**From:** [tiffany gorski](#)  
**To:** [Rachael Stevie \(CD\)](#)  
**Subject:** Project RU22-00002 East Peak Reasonable Use Variance  
**Date:** Friday, April 22, 2022 8:19:36 AM

I am writing in response to a letter I received regarding a variance request on parcel #961450. Here are a list of my concerns regarding this project:

EXHIBIT A - PROPOSED SITE PLAN

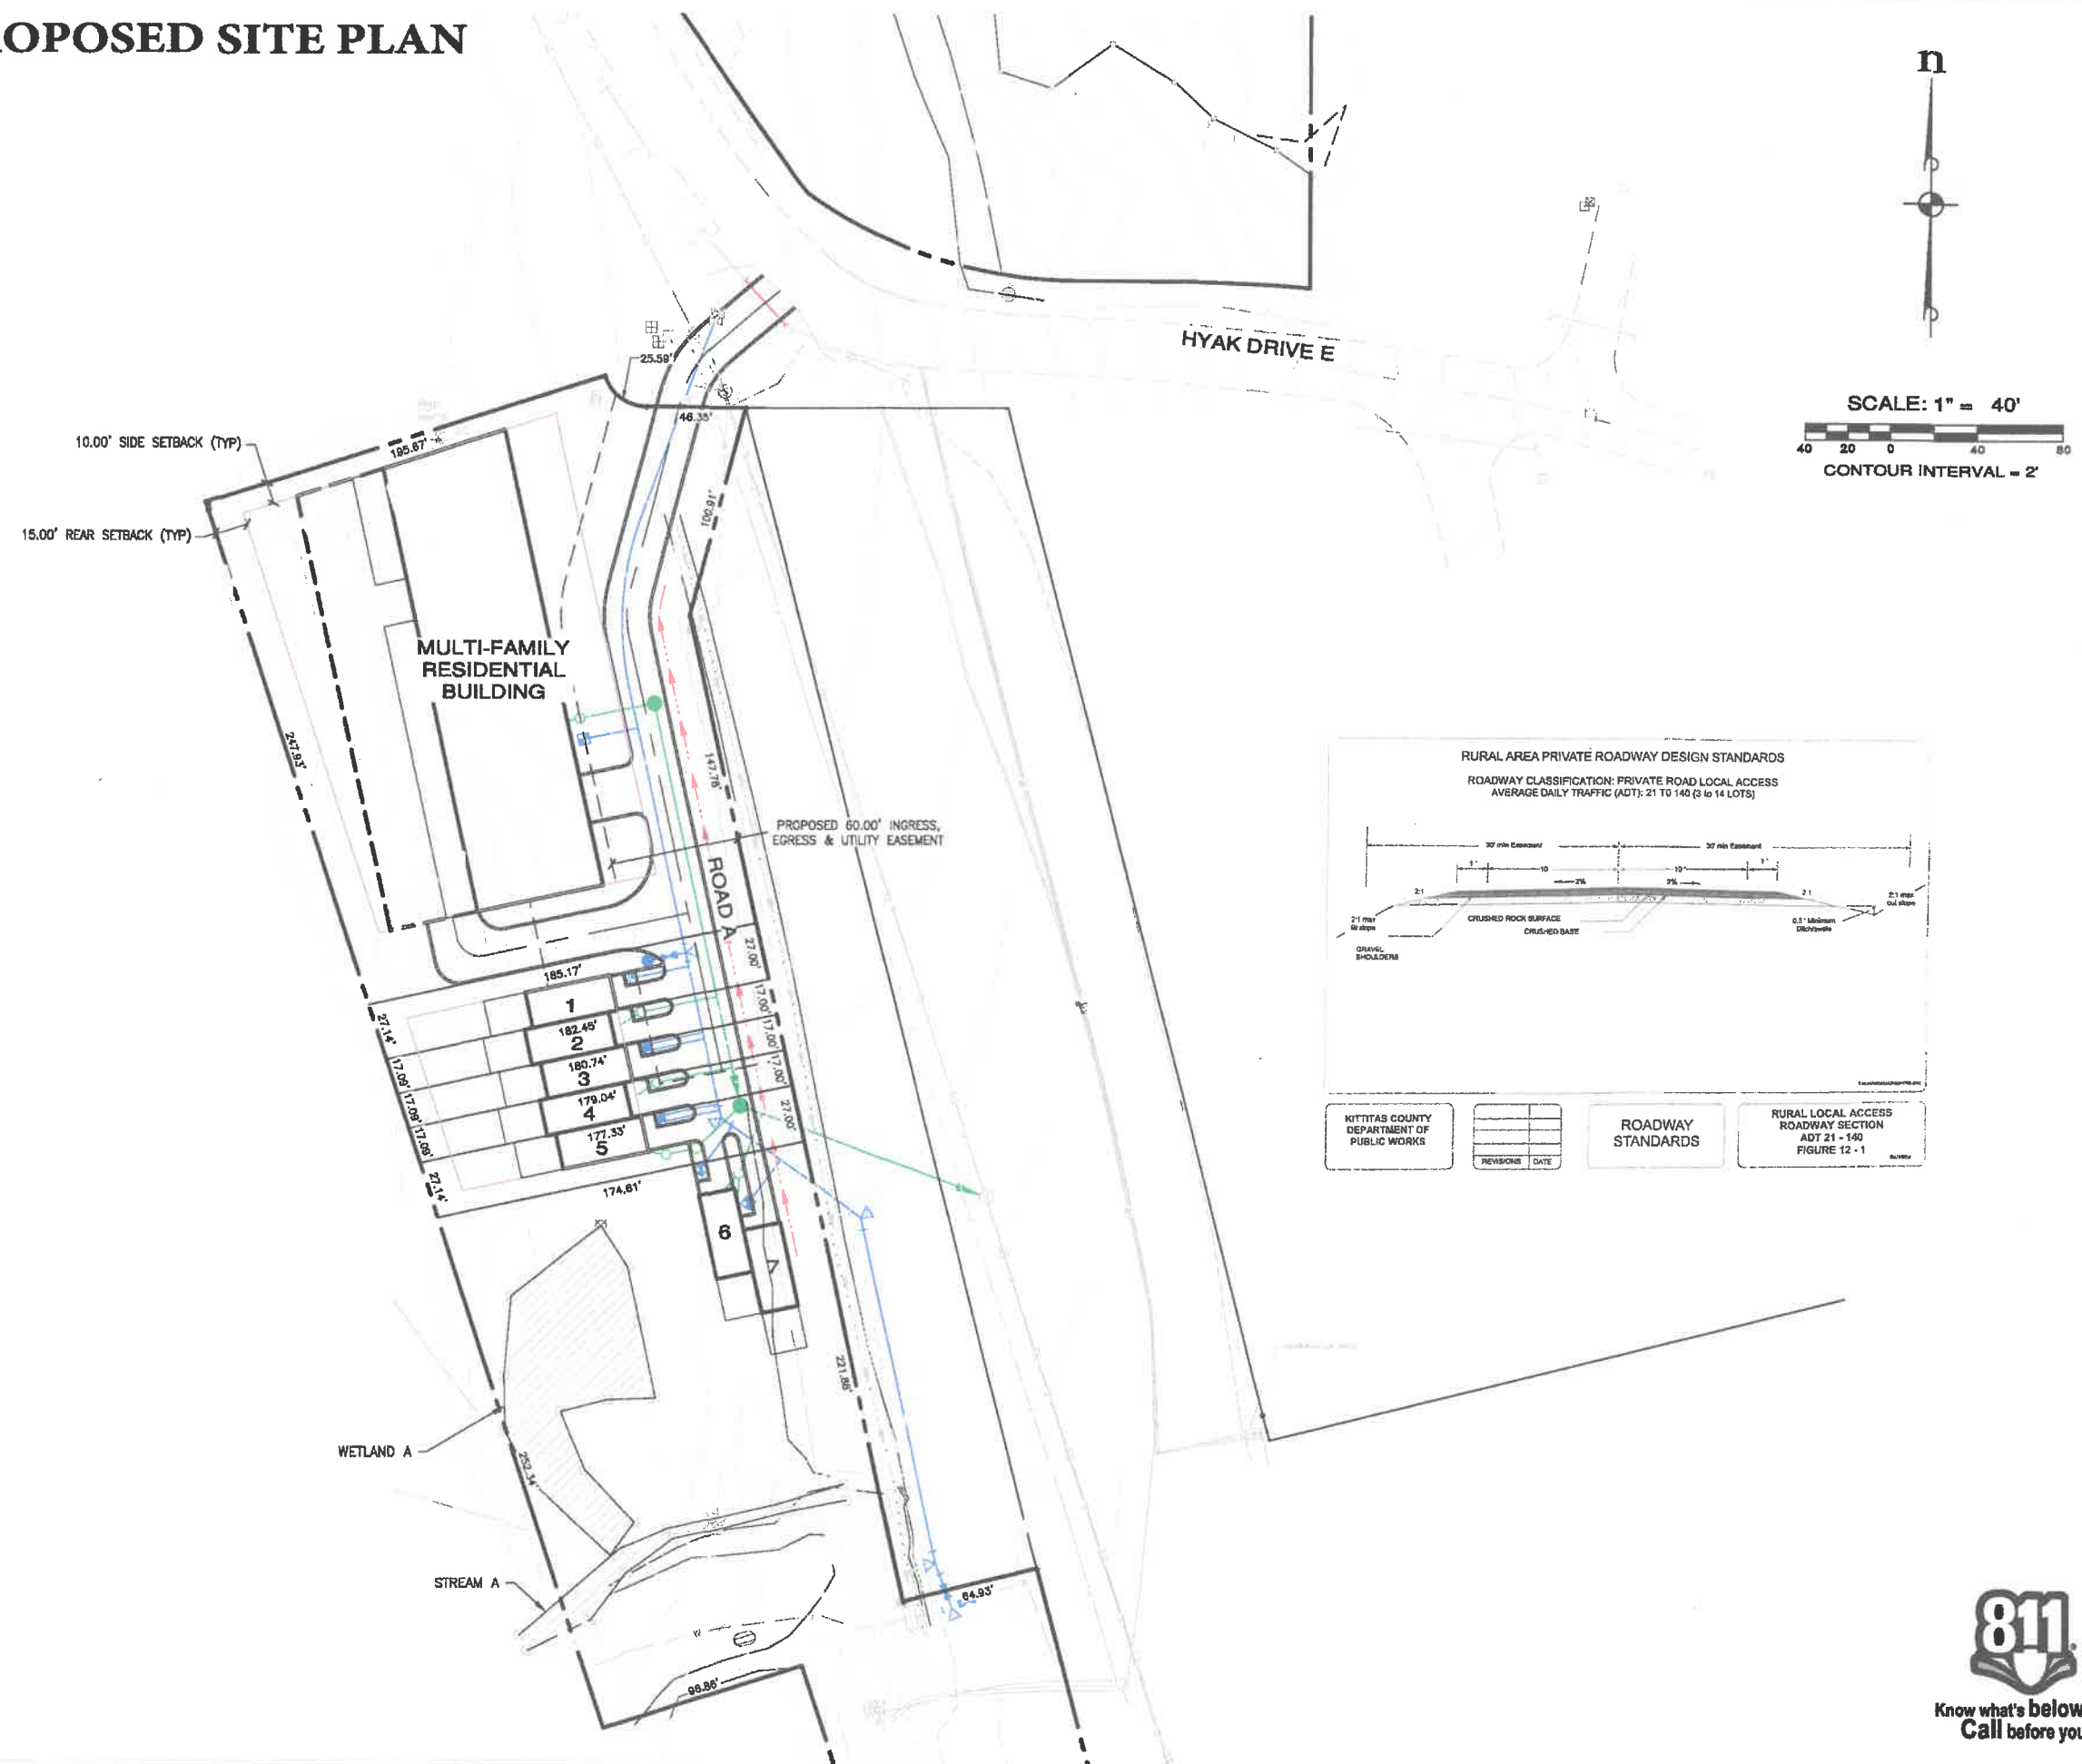
- Building closer to the hyak parking entrance will affect winter weekend traffic in and out of the parking lot. Currently, it is a tight fit for parking and driving around the parking lot on winter weekend days.
- Where will the snow removal go around the building? There does not seem room in the parking lot for extra piles of snow.
- Will the county be able to keep up with road maintenance with 100 additional cars on hyak drive?
- With more parking in the lower lot in the winter due to the building taking up space in the upper lot, will the county be able to keep up with plowing and sanding?
